City of Albuquerque Stormwater Construction Site Inspection Report

ESC File No.	M09E025A	Project Name:	Sage Ranch Subdivision		
NPDES Id. No.	NMR1003YW & NMR1004GM	Location:	9600 Sage Ranch Ct. NW		
2/14/2022	Owner/Developer	Owner/Builder			
Operator	Vuelo, LLC	Westway Homes			
Contact name & title	Gordon Rowe	Mike Feetz			
e-mail	growe@roelawfirmPC.com	mike@thewestway.com			
Contact Phone #	301-9431	304-8473			
COA Inspector	Doug Hughes	Start/End Time:	4pm		
Construction Phase:	House Construction				
Type of Inspection:	<input type="checkbox"/> Regular	<input type="checkbox"/> Storm Event	<input type="checkbox"/> Past Storm Event >0.25"	<input type="checkbox"/> 311/Complaint	<input checked="" type="checkbox"/> Follow Up
Weather at time of inspection?	clear		Temperature:	~	65
Estimated date of last storm 0.25" or greater	1/1/2022

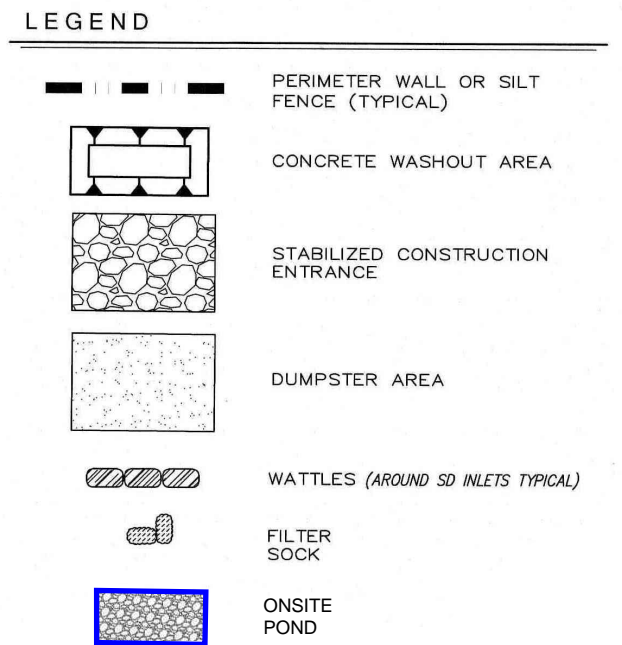
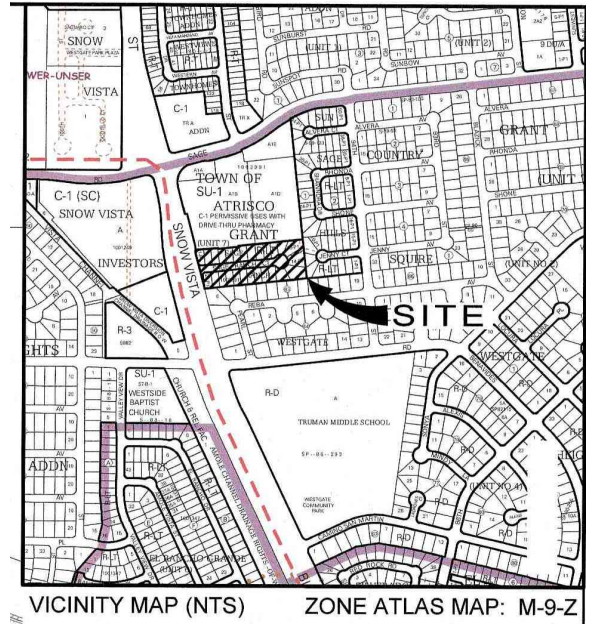
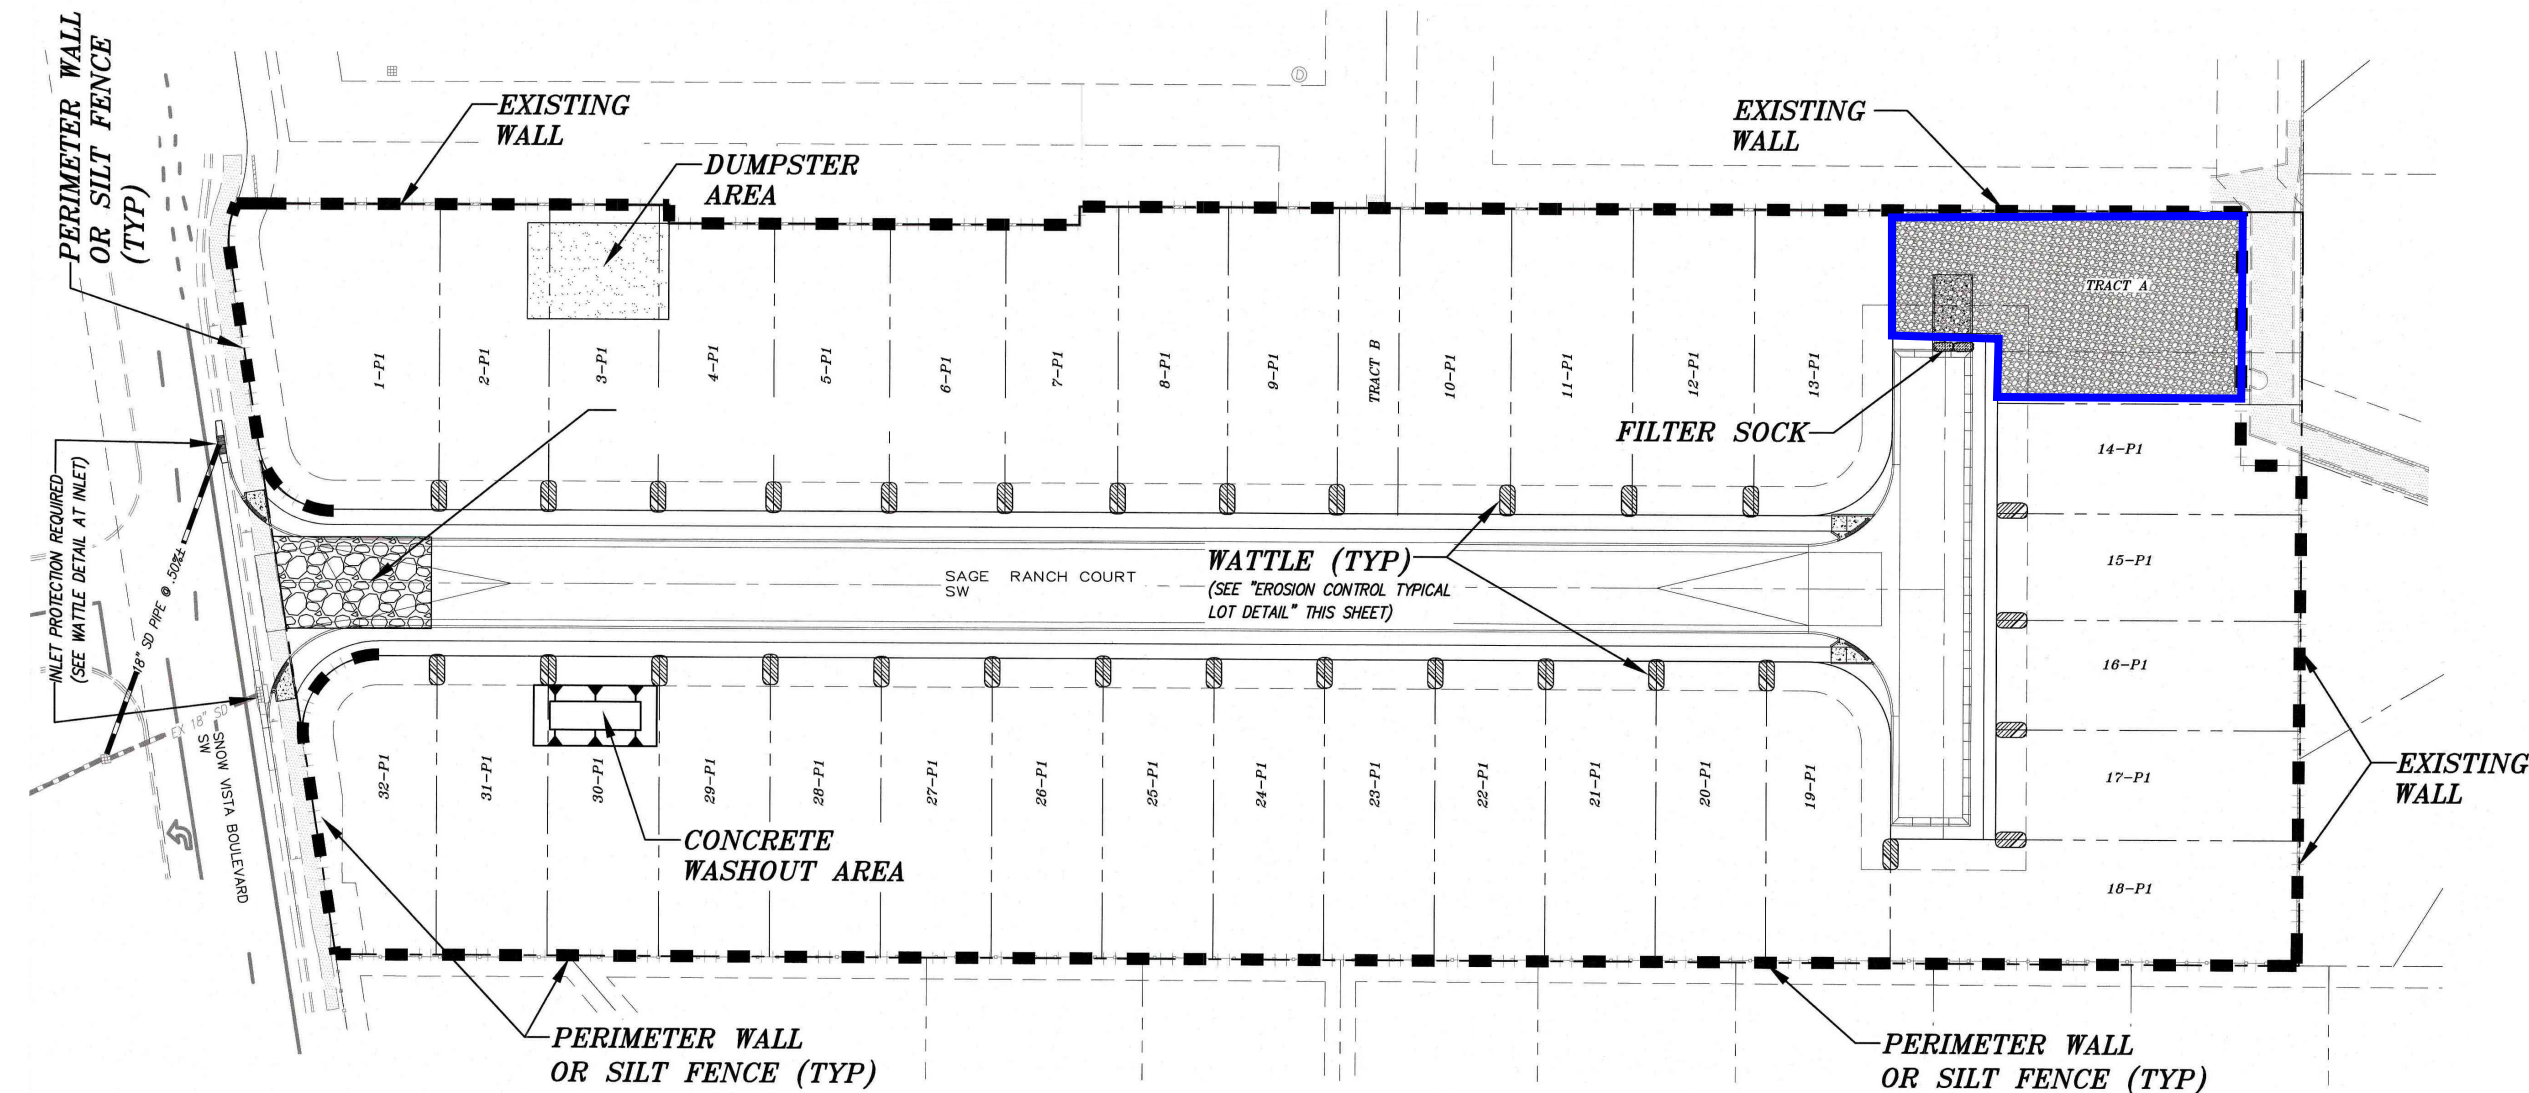
Item Number	Deficiency/ Corrective Action				
1	Washout needs picked up and disposed of, and all future paint, stucco, and concrete wash water must go into a lined container. There were no containers onsite.				
2	Waste was piled in drainage rundown in the northeast corner of the site, and there wasn't any waste container on-site. Place waste in covered container.				
3	The up-to-date SWPPP apparently wasn't available onsite since its location was not indicated on the posting. The SWPPP must be kept up-to-date and available onsite per CGP 7.1. If an on-site location is unavailable to keep the SWPPP when no personnel are present, notice of the plan's location must be posted near the main entrance of your construction site CGP 7.3. The SWPPP for NMR1003YW is needed immediately and NMR1004GM after Westway Homes buys the lots.				
	Discharge off site? (Y/N)	no			
4	Self Inspection Reports	?	Latest report Date:	?
